Our Ref: 2397/RLP/01

APPLICATION NO 2023/92066 - ERECTION OF TWO SEMI DETACHED DWELLINGS WITH ASSOCIATED ALTERATIONS AT 89 WHITCLIFFE ROAD, CLECKHEATON

Ground Floor Plan 1:50

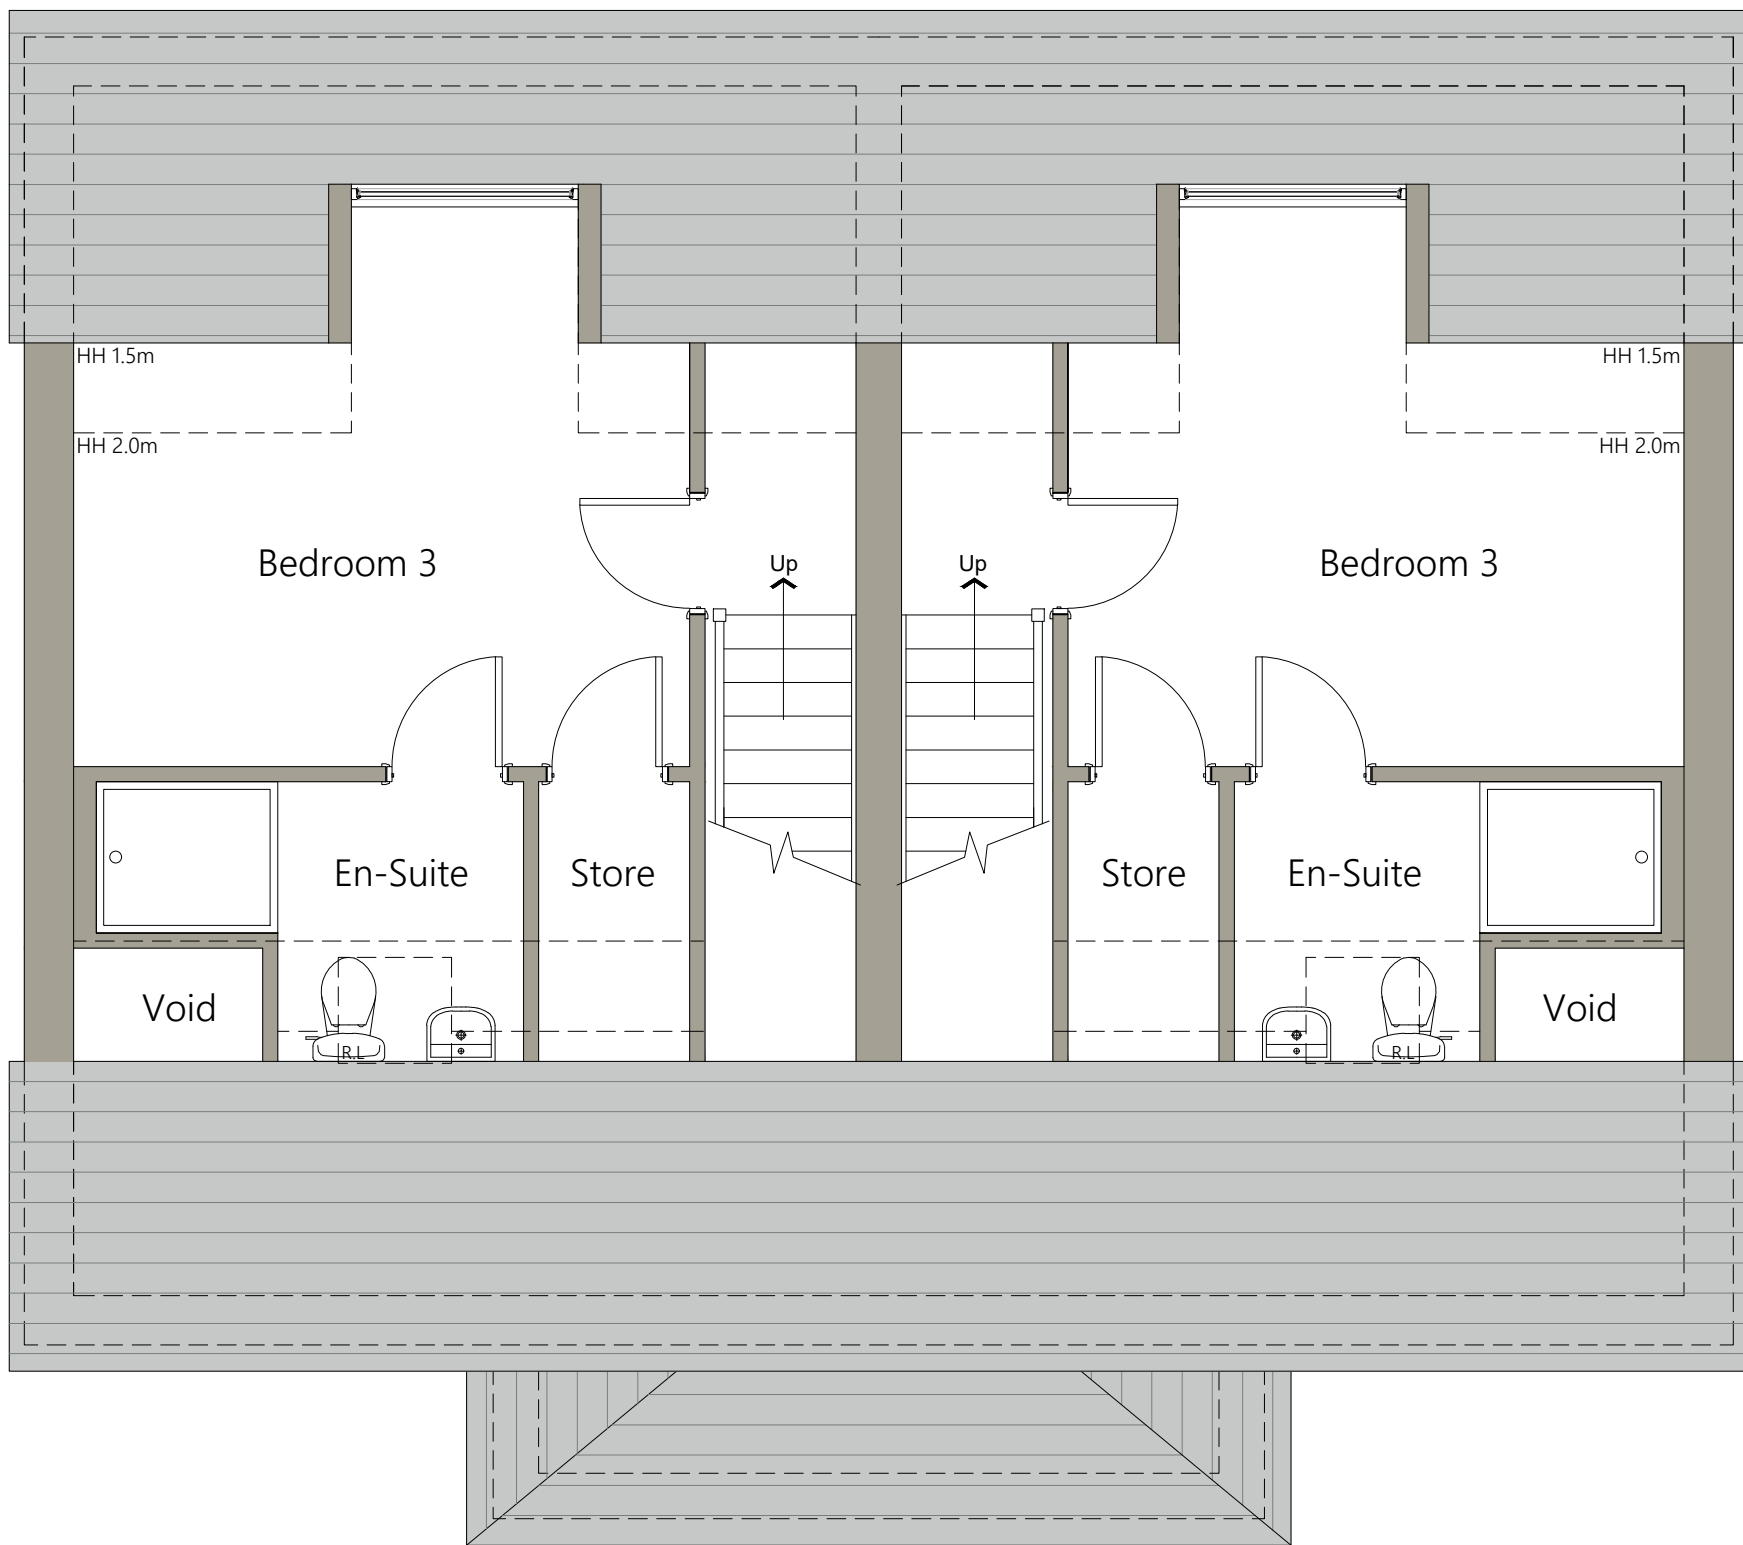
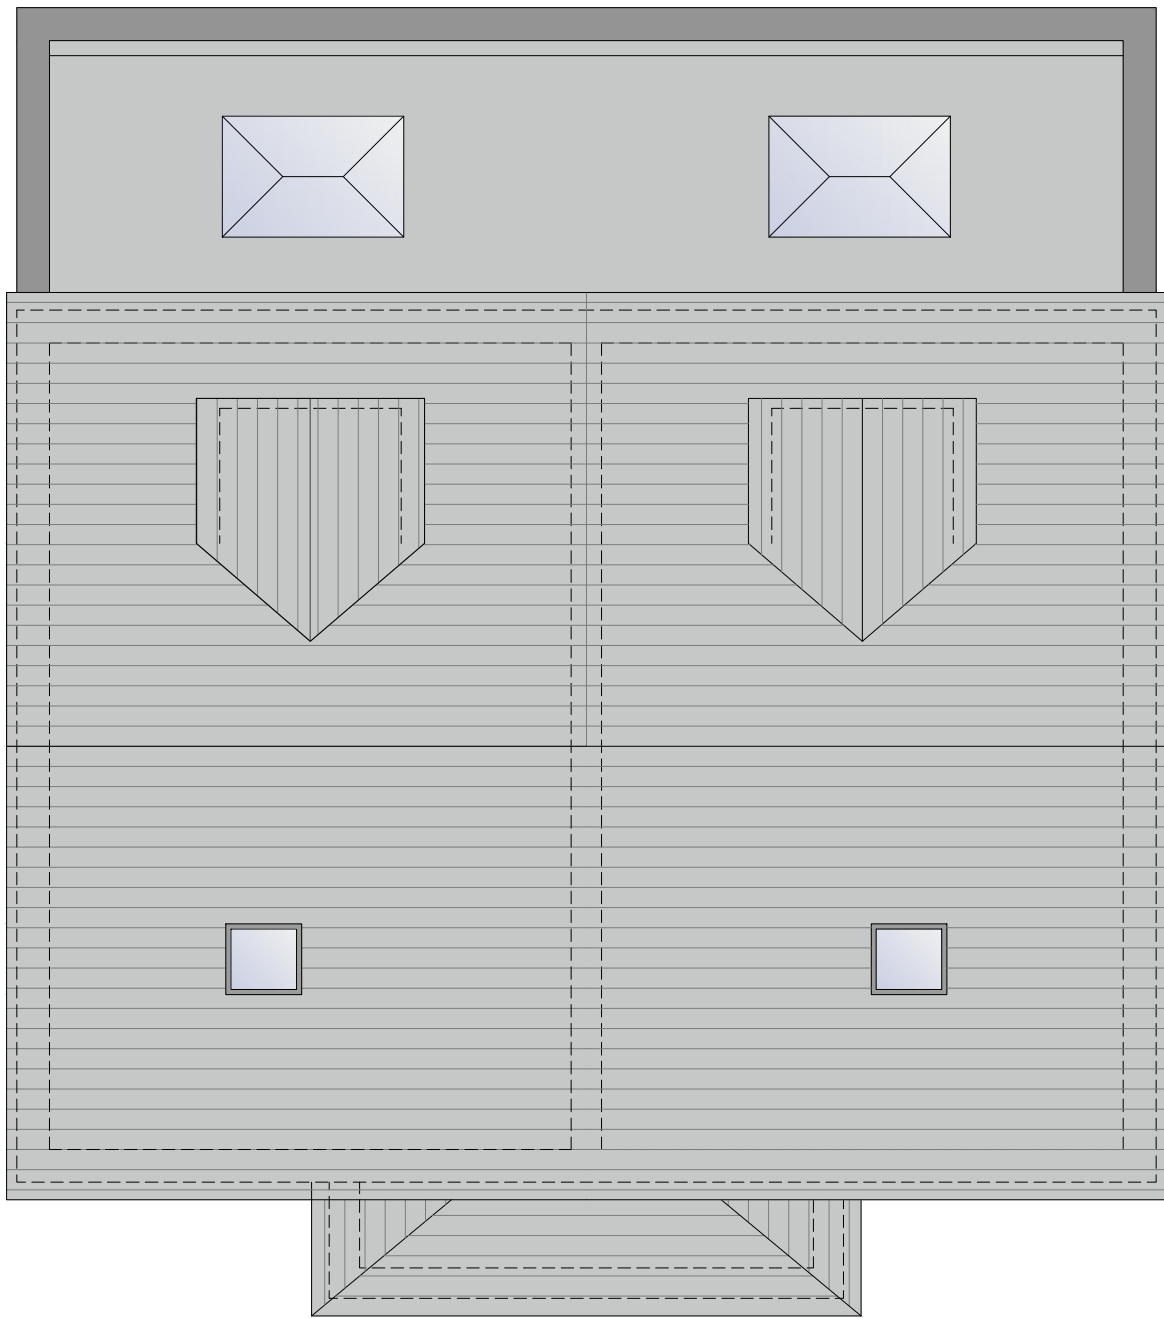
The proposed plans show a pair of 3 bed semi-detached houses, potentially 4 beds given that a study is indicated for each plot.

It is noted also that kitchen windows are shown in the side elevation of the plot facing towards Grove House. Whilst the drawings indicate that these will be obscure glazed this is not an ideal solution to overcome what is a shortfall in minimum distance standards. Such windows could easily be changed to clear glass in the future and a better solution would be to have the windows at a high level to prevent any potential conflict.

Site Plan 1:200

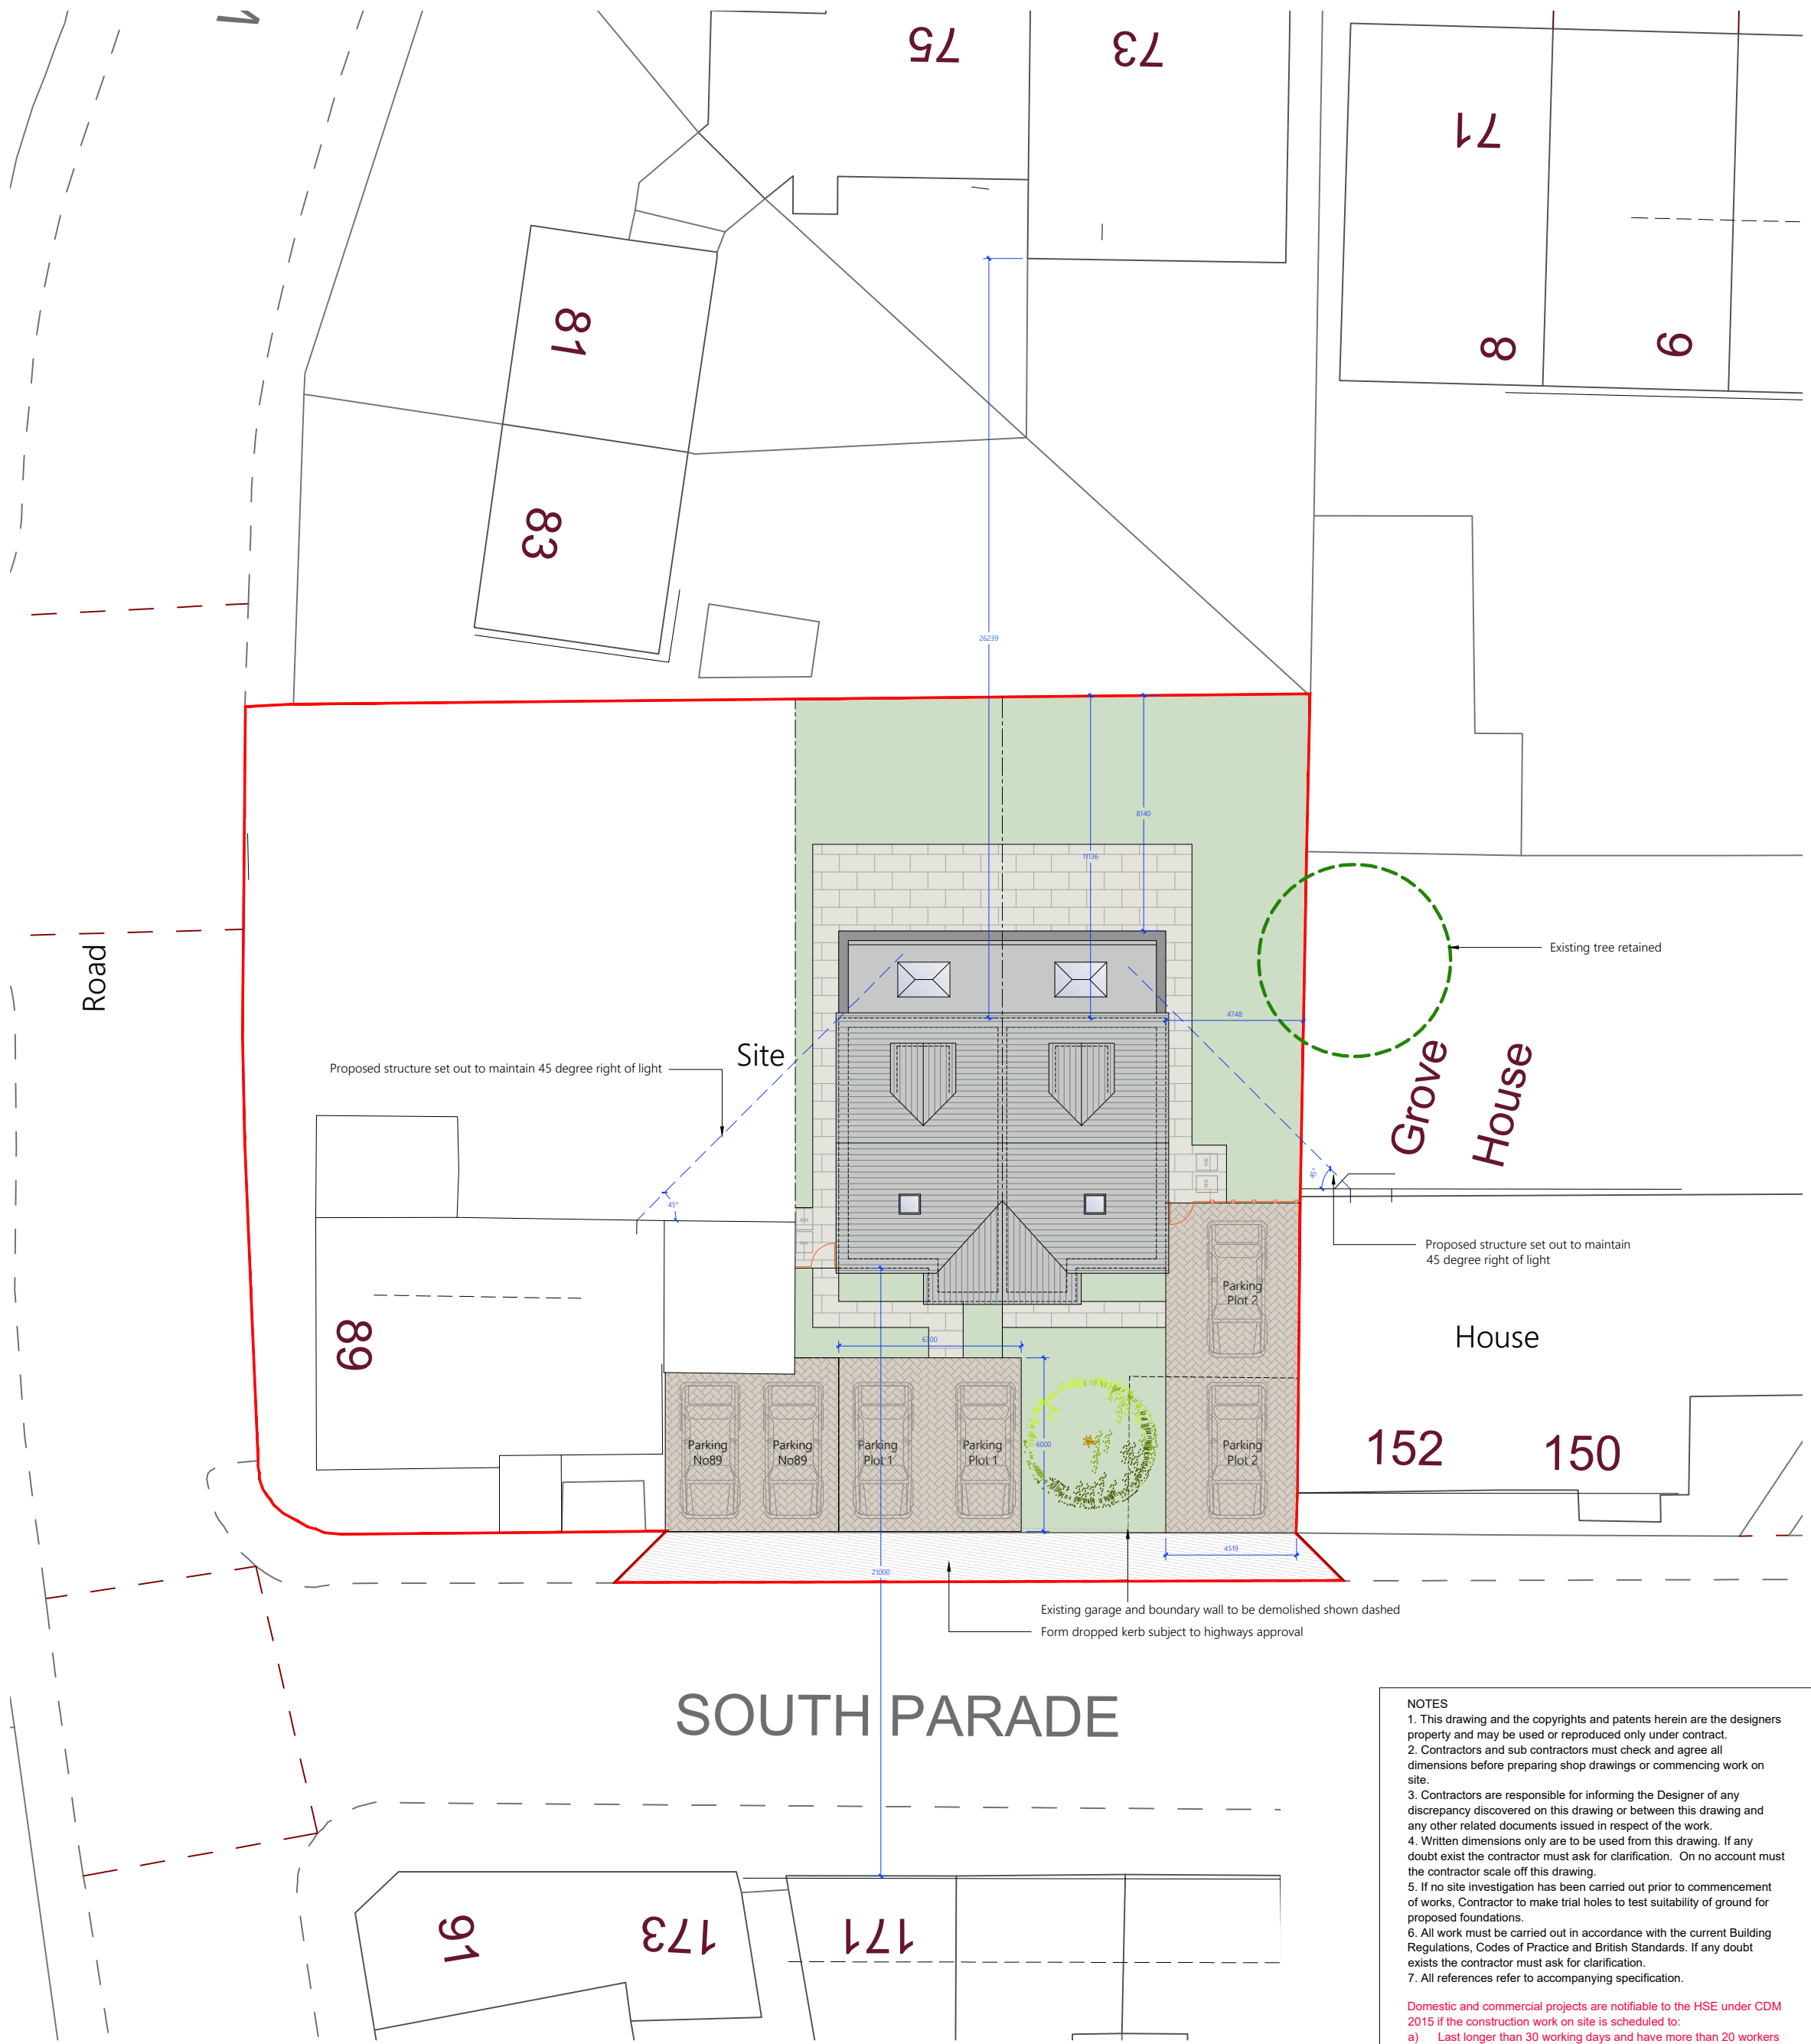
The plans have been amended to include 7 parking spaces, two each for the semi-detached plots and three for the existing dwelling at No 89. As originally submitted the plans showed six parking spaces to the front of the dwellings. The parking spaces are now shown to the rear of the site.

The siting of the dwellings just 1.6m from the boundary with Grove House (noting that Grove House's side elevation forms part of the southern boundary) would have a significant impact on the amenity of Grove House through overshadowing and overdominance. It would also create problems in the future in terms of their being insufficient room for maintenance of Grove House and also potential fire spread risks from the closeness of the two properties.

In order to resolve the objections raised in the initial consultation response from Kirklees highways, the impact of providing parking at the rear of the site, has resulted in garden space being lost. For three bedroom dwellings, the level of garden space provided is inadequate and would not provide a high standard of amenity for future occupants, contrary to paragraph 130.

The parking layout, whilst in theory providing sufficient parking for the houses, is by necessity of the siting of the dwellings, set out in a tandem form, which in practice does not work and would likely result in vehicles parking on the roadside rather than in the spaces proposed. The provision of pedestrian footpaths to the dwellings at the front from South Parade would also encourage roadside parking. South Parade is full of cars during peak school times in the morning and afternoon, and this also becomes the case in the
